The Drax Power (Generating Stations) Order

Environmental Statement Appendix 1.2 - Scoping Opinion

SCOPING OPINION

Proposed Drax Repower Project

DRAWING No: 70037047-3.5	REV: A
-----------------------------	-----------

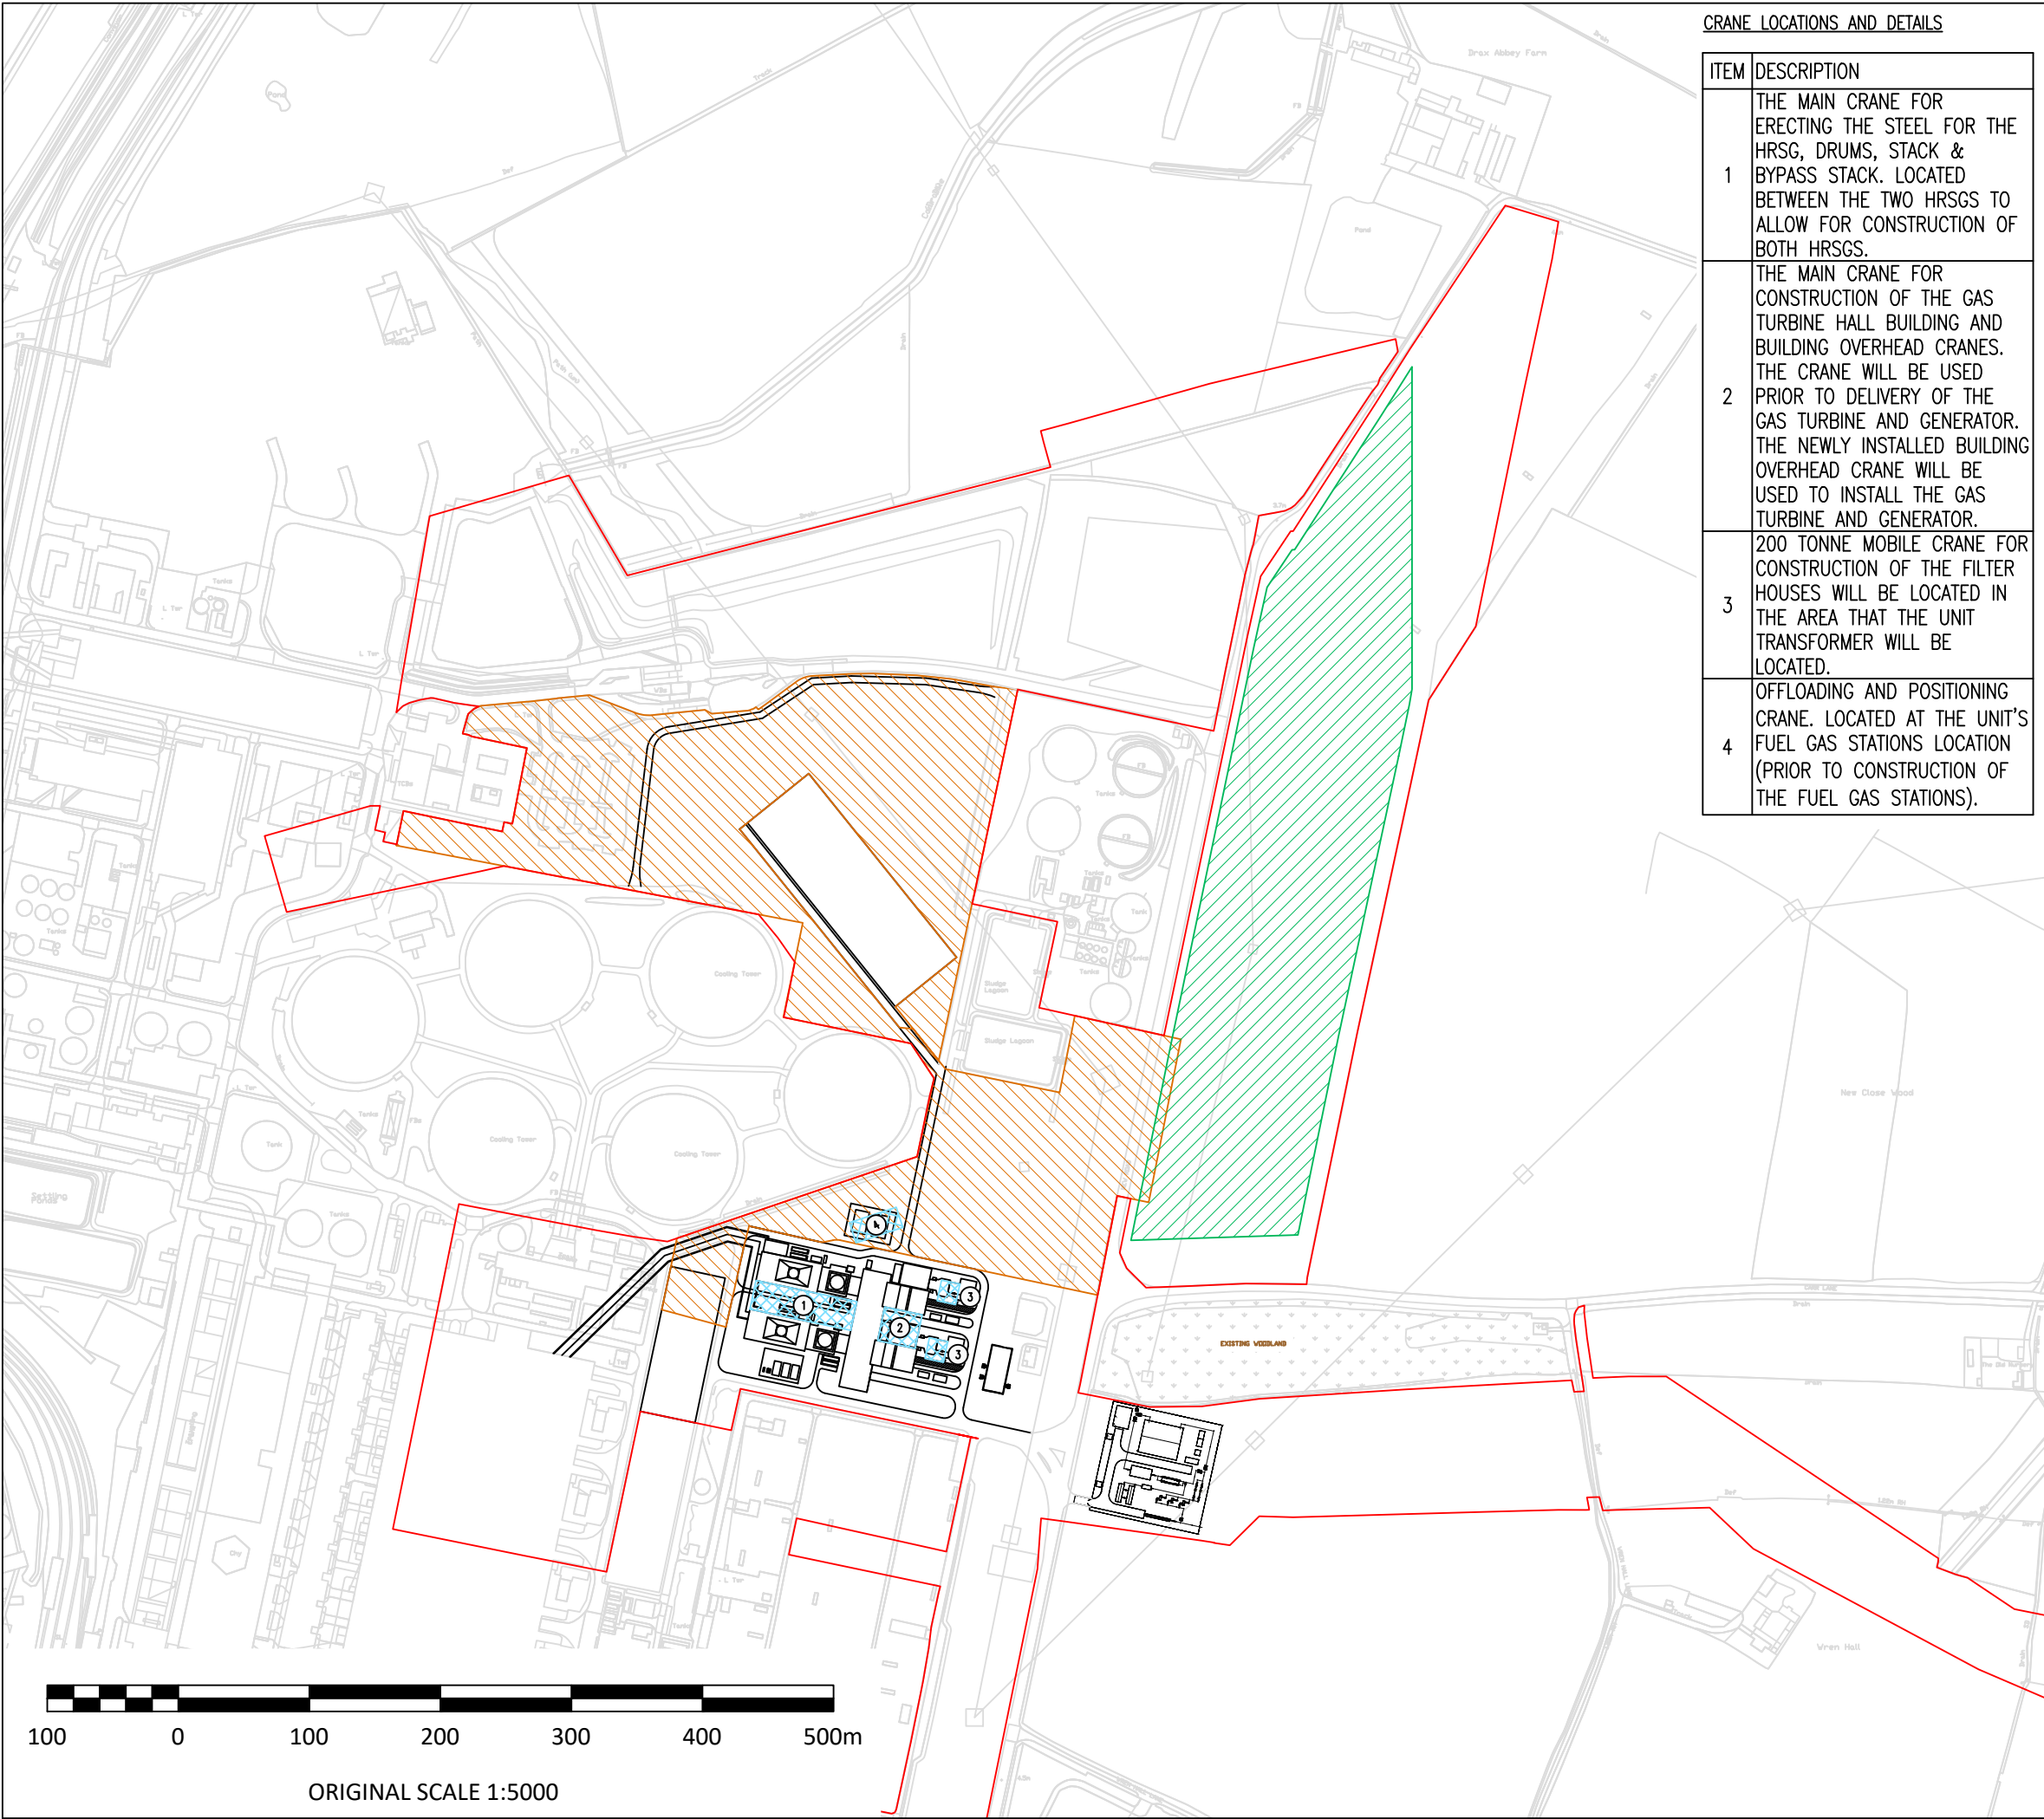
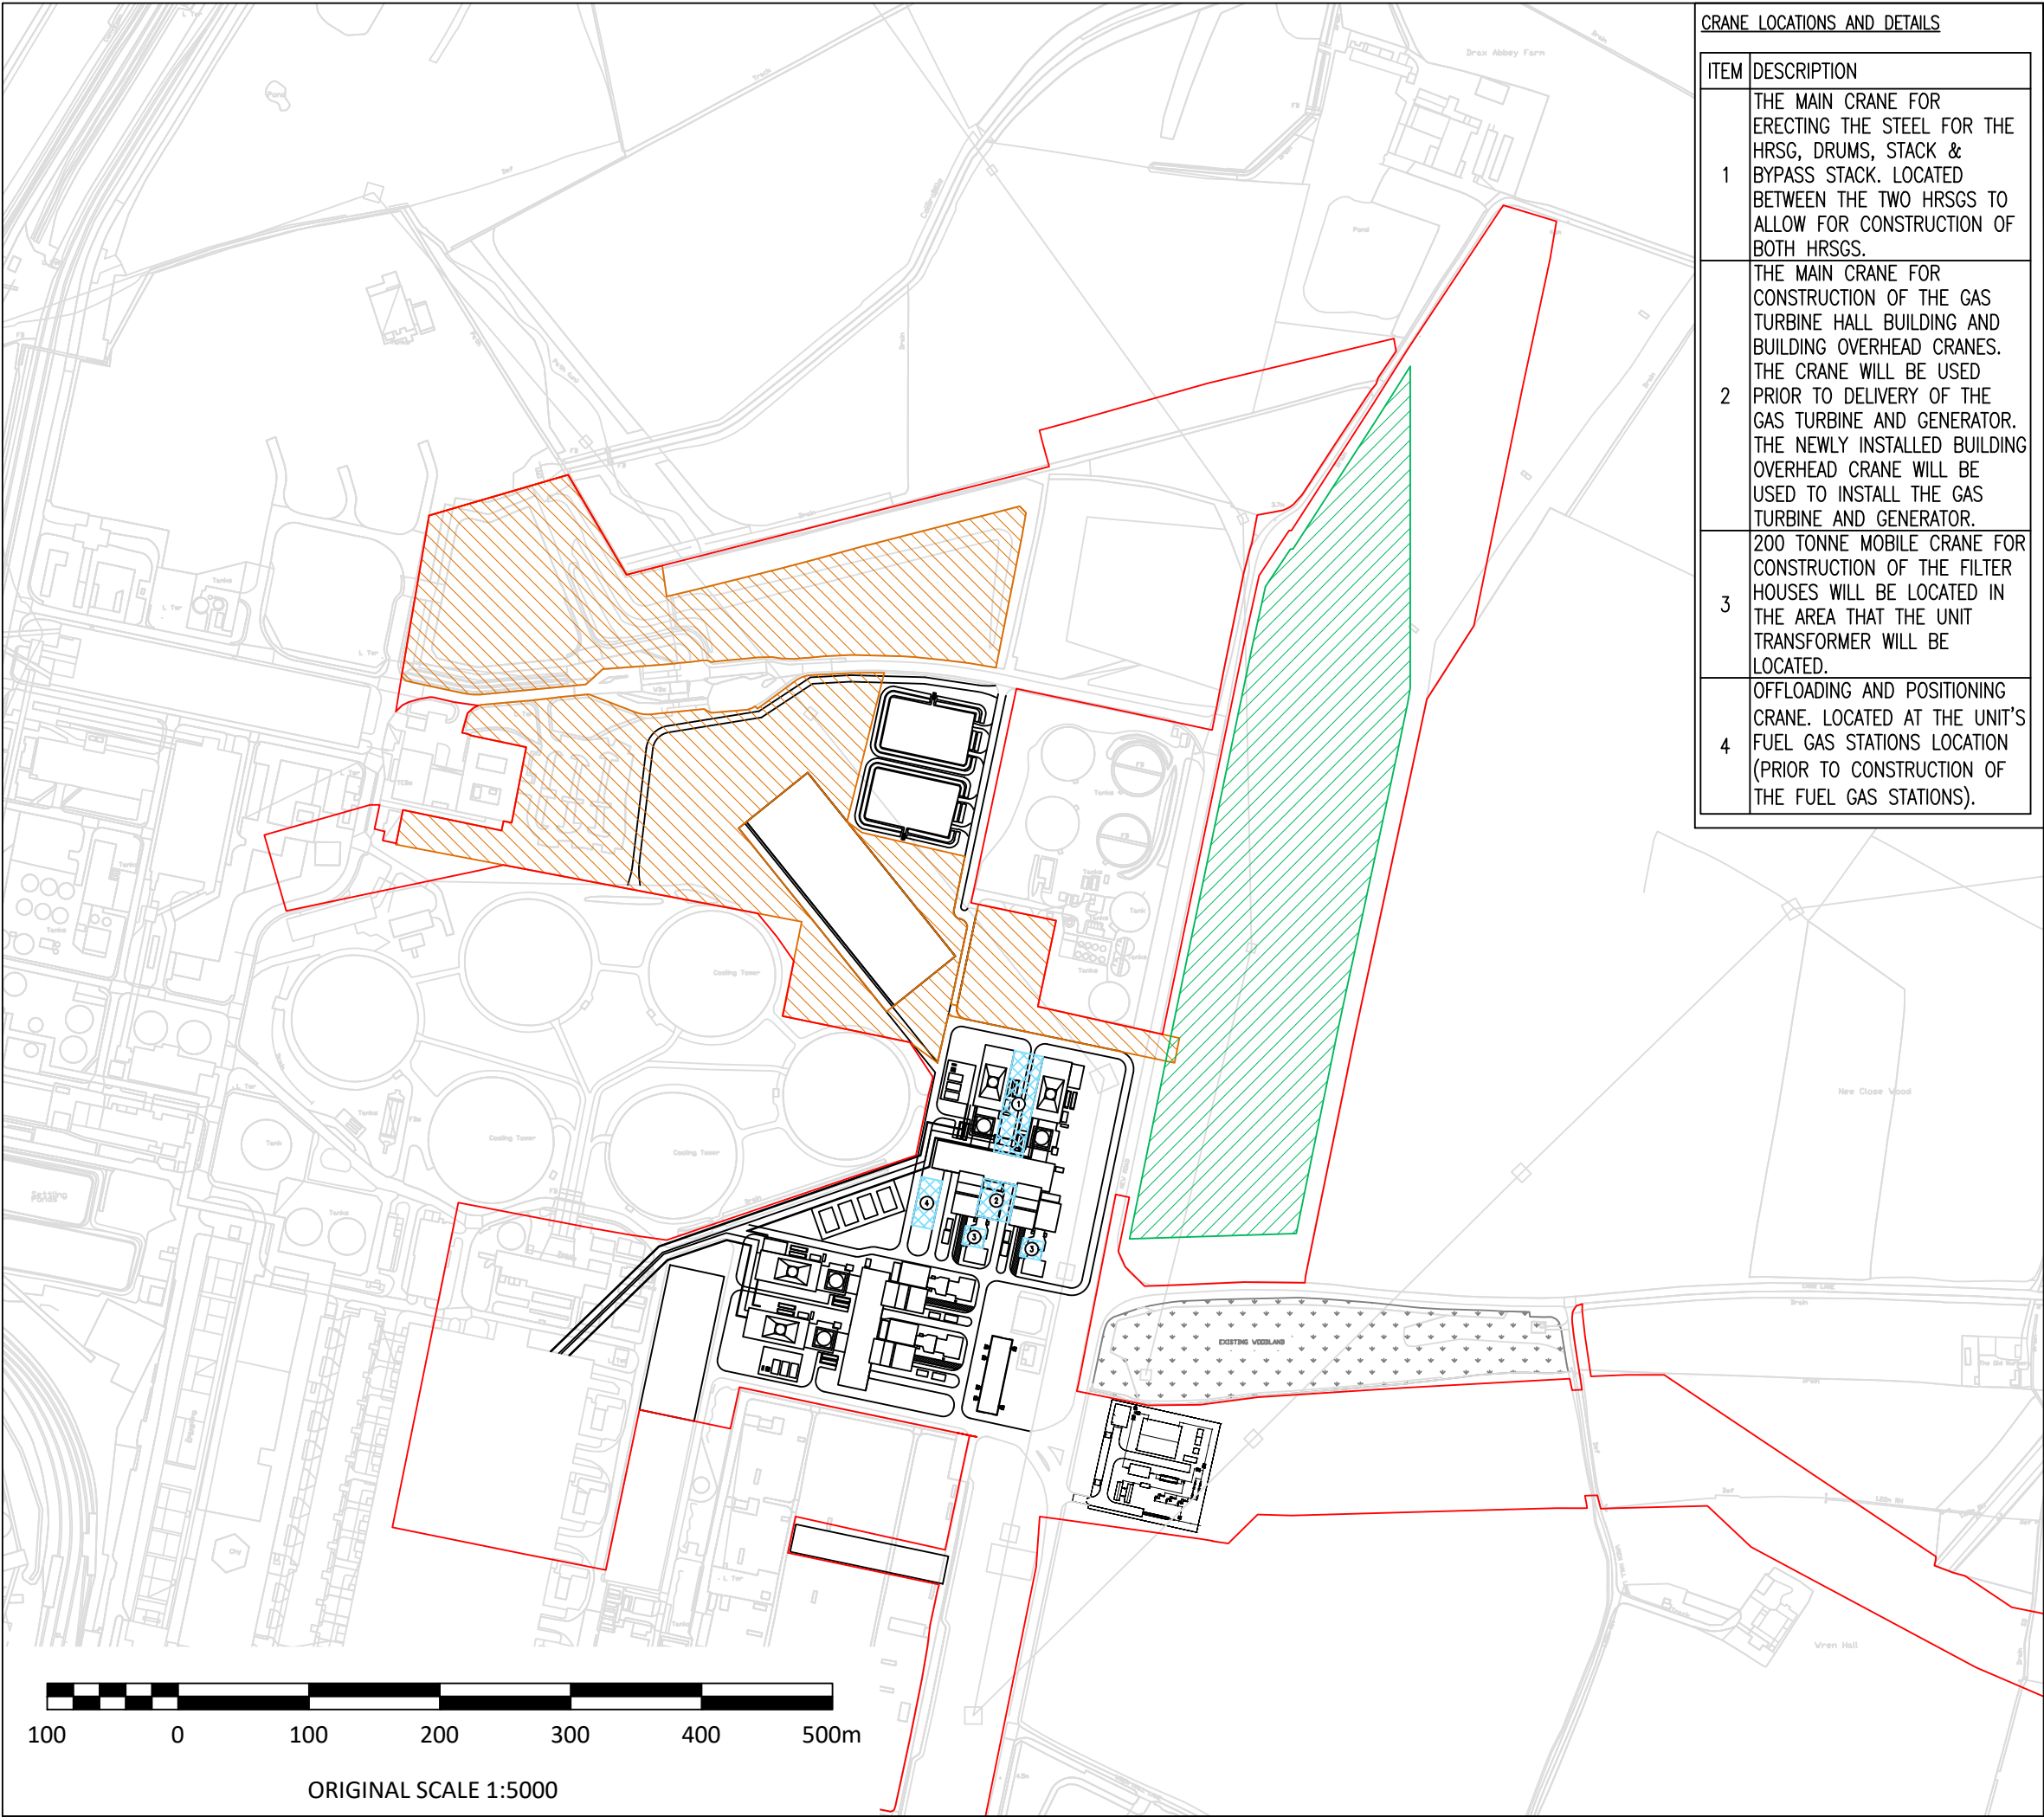
- 2.3.4 The Scoping Report identifies temporary construction-related structures, e.g. a mobile crane (which would be utilised alongside an existing jetty) and a temporary pedestrian bridge. The ES should identify the likely dimensions associated with these structures and the duration of their use. Any works required to facilitate the use of the jetty (e.g. to the existing roads or vegetation) should also be described.
